REP7-020 Outline Construction Traffic Management Plan (oCTMP)

Barred Routes – Request to Nottinghamshire County Council, as the relevant highway authority.

Figure 4.1: Barred Route Plan

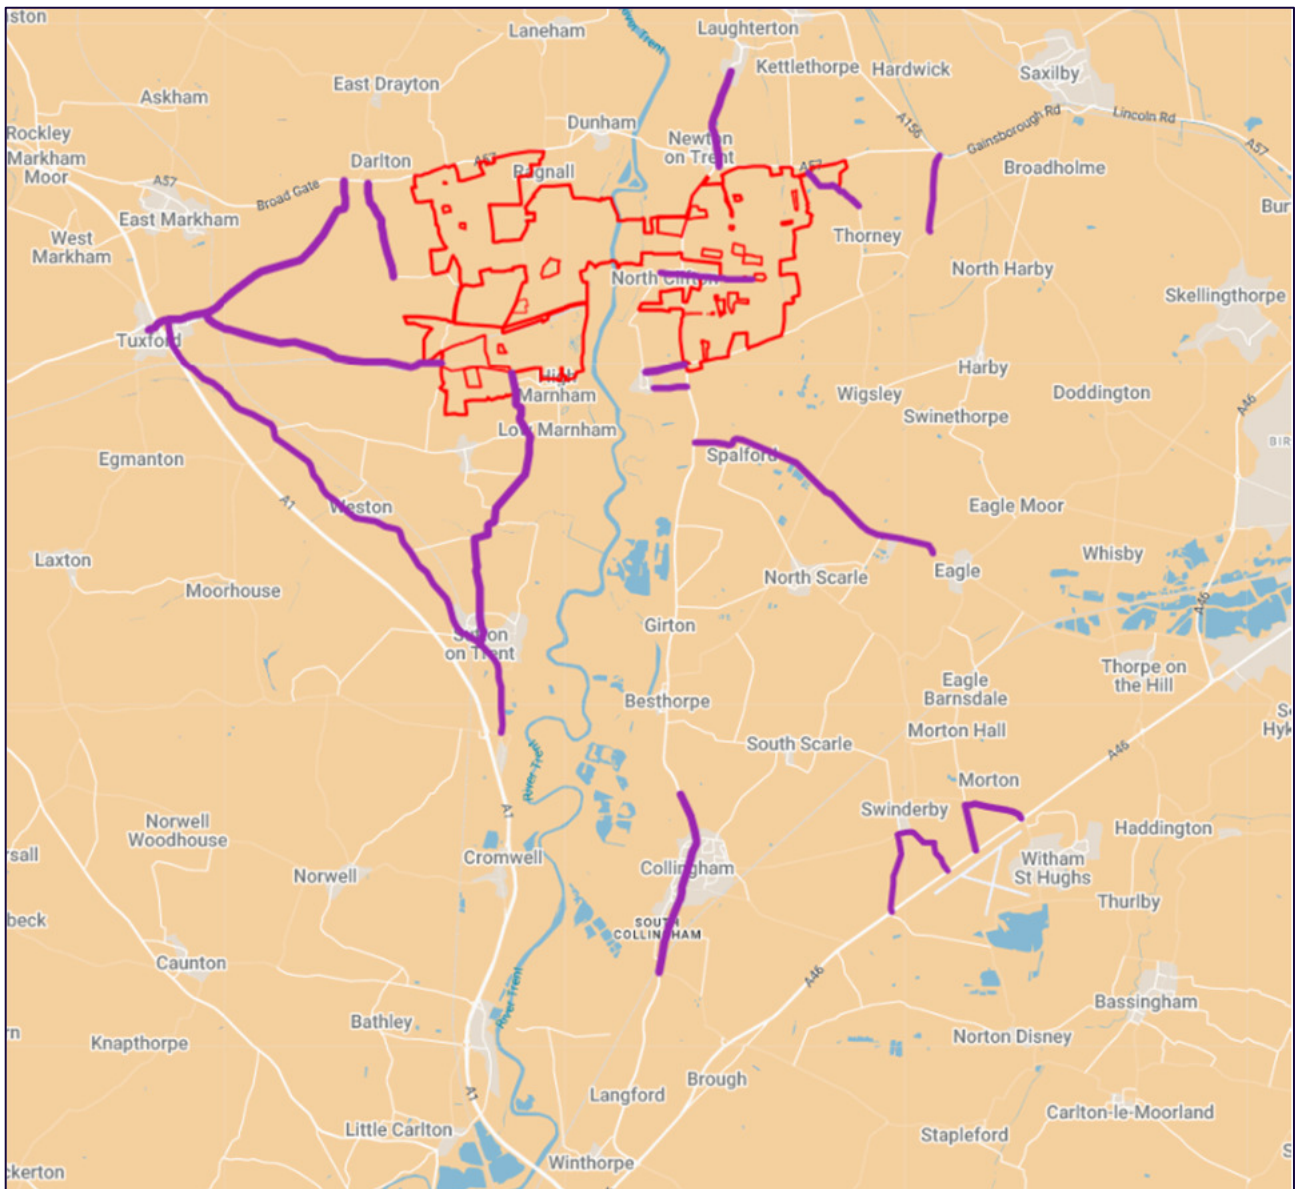
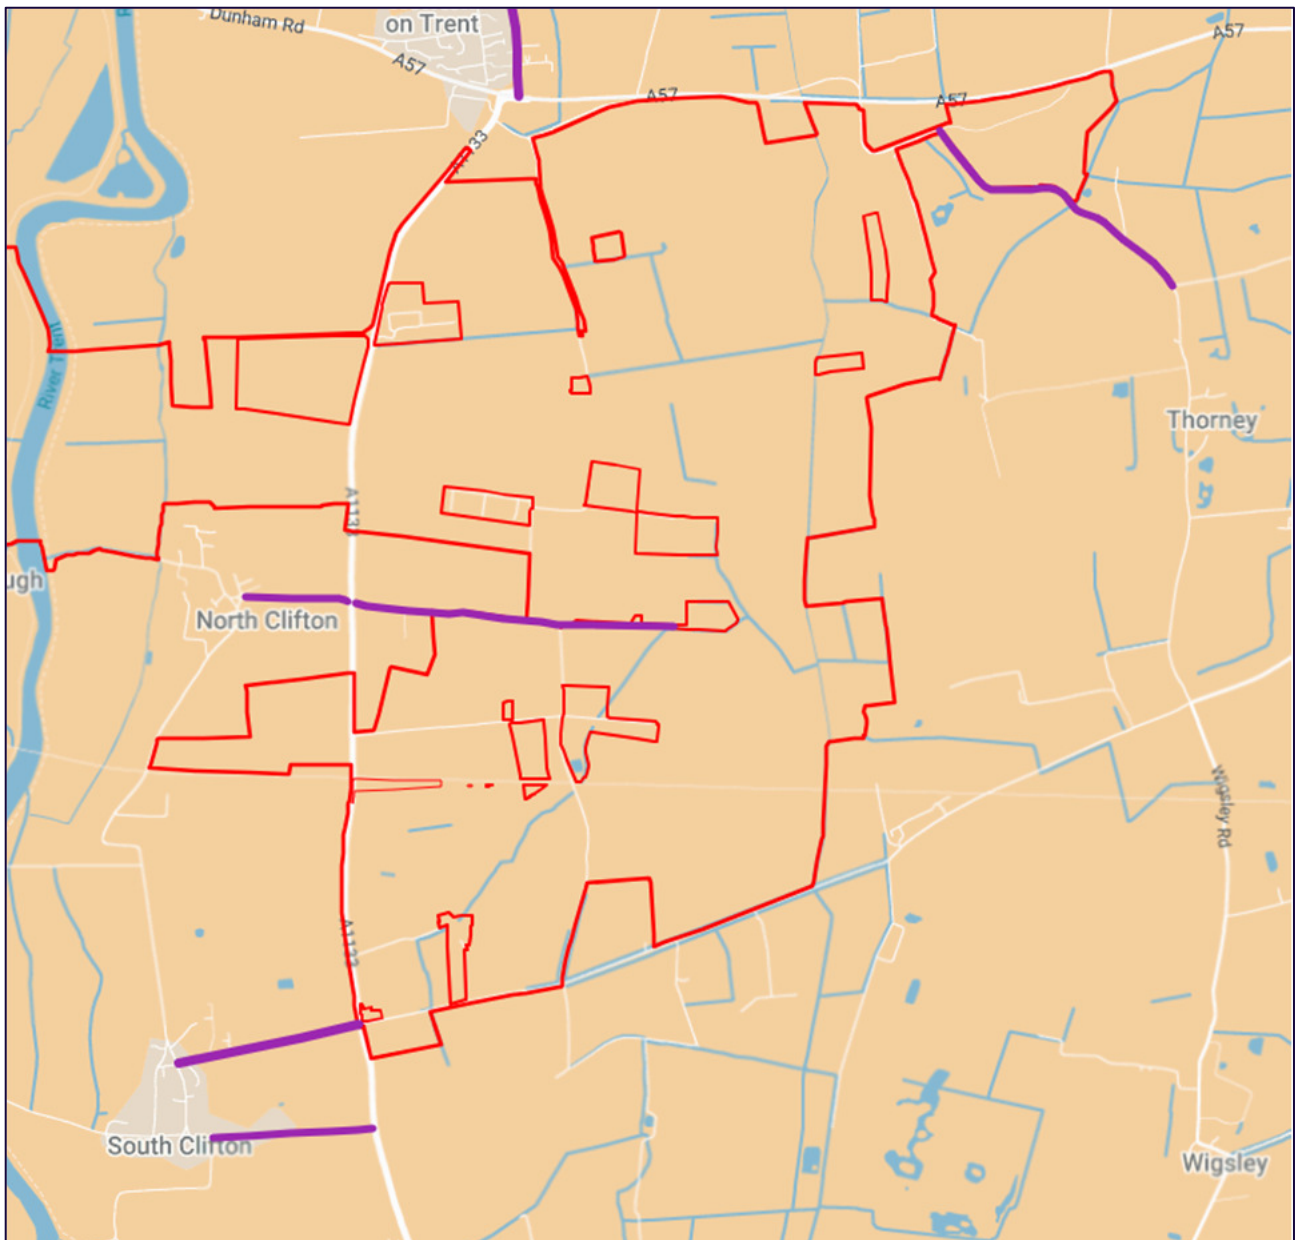
The Applicant has not seen the need to include Moor Lane, North Clifton as a barred route, as requested in my previous submission REP5-108. Whilst it is noted that it will only be used as an access point crossing over Moor Lane the same as a certain point on Cottage Lane, this will not mean construction or site traffic will be barred from using these 2 lanes to access other areas of the site, for example the easterly end of Moor Lane, running in front of Moor Farm, where there is a planned Site Compound.

As The Applicant is not willing to accept my request to include Moor Lane, North Clifton as a barred route to the oCTMP as was discussed in the early planning stages between Mr and Mrs Walker and Mr Daniel Boyd (One Earth Project Lead) on a site visit to Moor Farm, North Clifton where myself and my husband were assured Moor Lane would not be used by Construction or Site Traffic.

I would therefore respectfully request for Nottinghamshire County Council, as the relevant highway authority, to review my request and have The Applicant include within REP7-020 7.9.5 Outline Construction Traffic Management Plan (Clean) (Rev 6), the full length of Moor Lane, North Clifton as a barred route, with the acceptance of the crossing point as required by The Applicant to access the adjacent land within their order limits. This would be due to it not being suitable for construction and site traffic, especially with the lack of visibility at the junction with the A1133 and it being a single tracked lane with zero passing points and an already poor road surface. Thank you.
